Department of Primary Industries

Ravensworth Operations Project (DA09_0176 MOD 2) Proposed Modification

Comment by NSW Office of Water

FIGURE 3

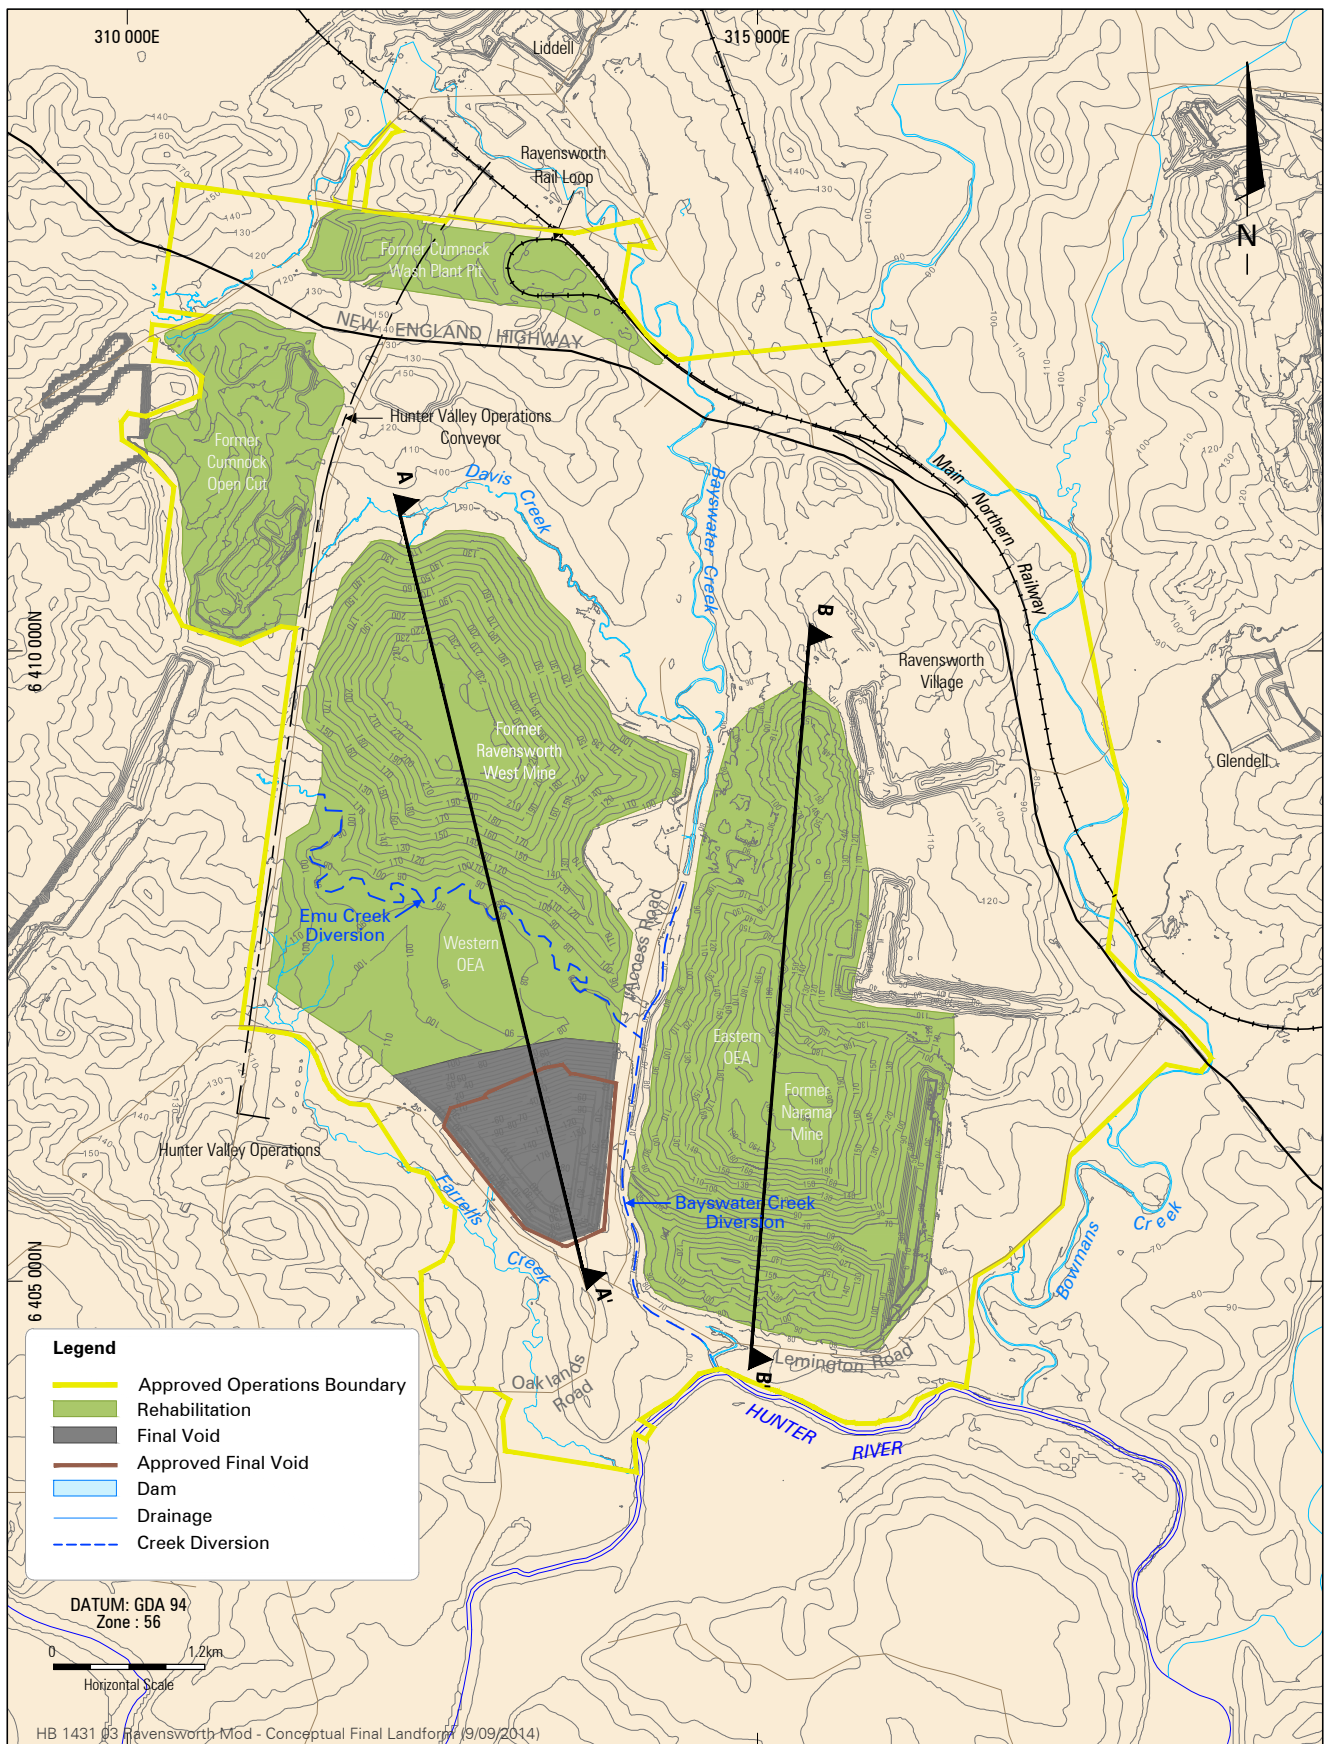
The Office of Water notes from Figures 3 and 4 of the EA that the revised final landform would result in changes to the size and shape of the final void. This may have implications for ongoing groundwater inflows to the void which is predicted to act as a groundwater sink. The commitment to continue to manage operations in accordance with the Ravensworth Operations Water Management Plan is noted. The Office of Water requests that the plan be amended to incorporate the modification, including an evaluation of the impacts of the modification on long-term groundwater inflows.
